DEVIATION REQUEST AND DECISION FORM

Project Name :	Sterling Ranch Sand Creek Channel Construction Drawing Review CDR 20-4
Schedule No.(s) :	5227301021, 5233309027, 5228000030 & 38, 5233301001 5233301016 &17
Legal Description :	See Exhibit B – Legal Description

A deviation from the standards of or in Section **ECM section 3.3.3 Open Channel Design Standards** of the Engineering Criteria Manual (ECM) is requested for the Sand Creek Channel Design – Low Flow Channel Bottom Width.

Typical Channel Cross Section

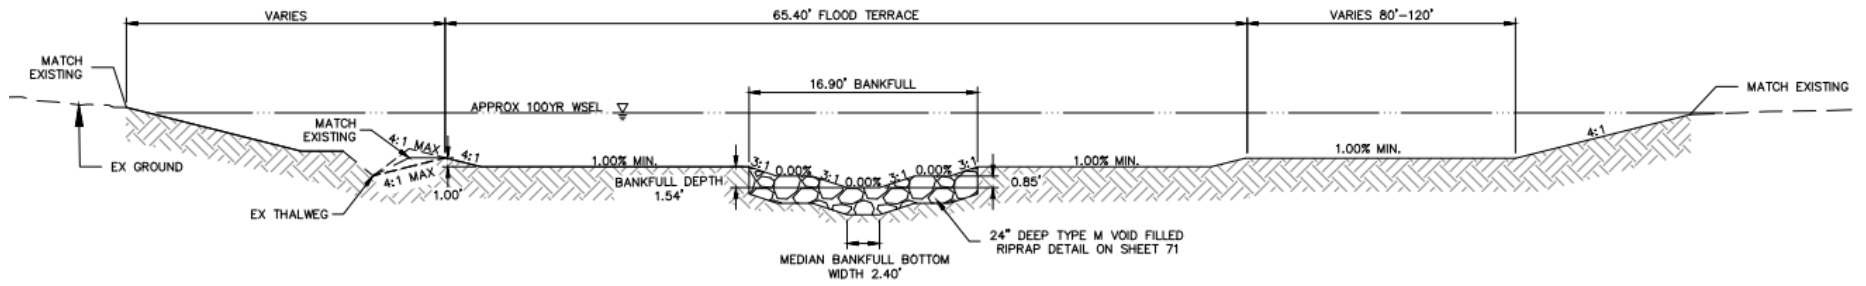
See Exhibit A for a representation of the “geomorphologist recommended” low flow channel cross section along with additional DCM 1 criteria excerpts.

The proposed low flow channel bottom width in the Sterling Ranch Sand Creek design is approximately 2.4 feet wide. The low flow channel is armored with 24” deep type M void filled rip rap.

Maintenance of the low-flow channel shall be by the Sterling Ranch Metro District.
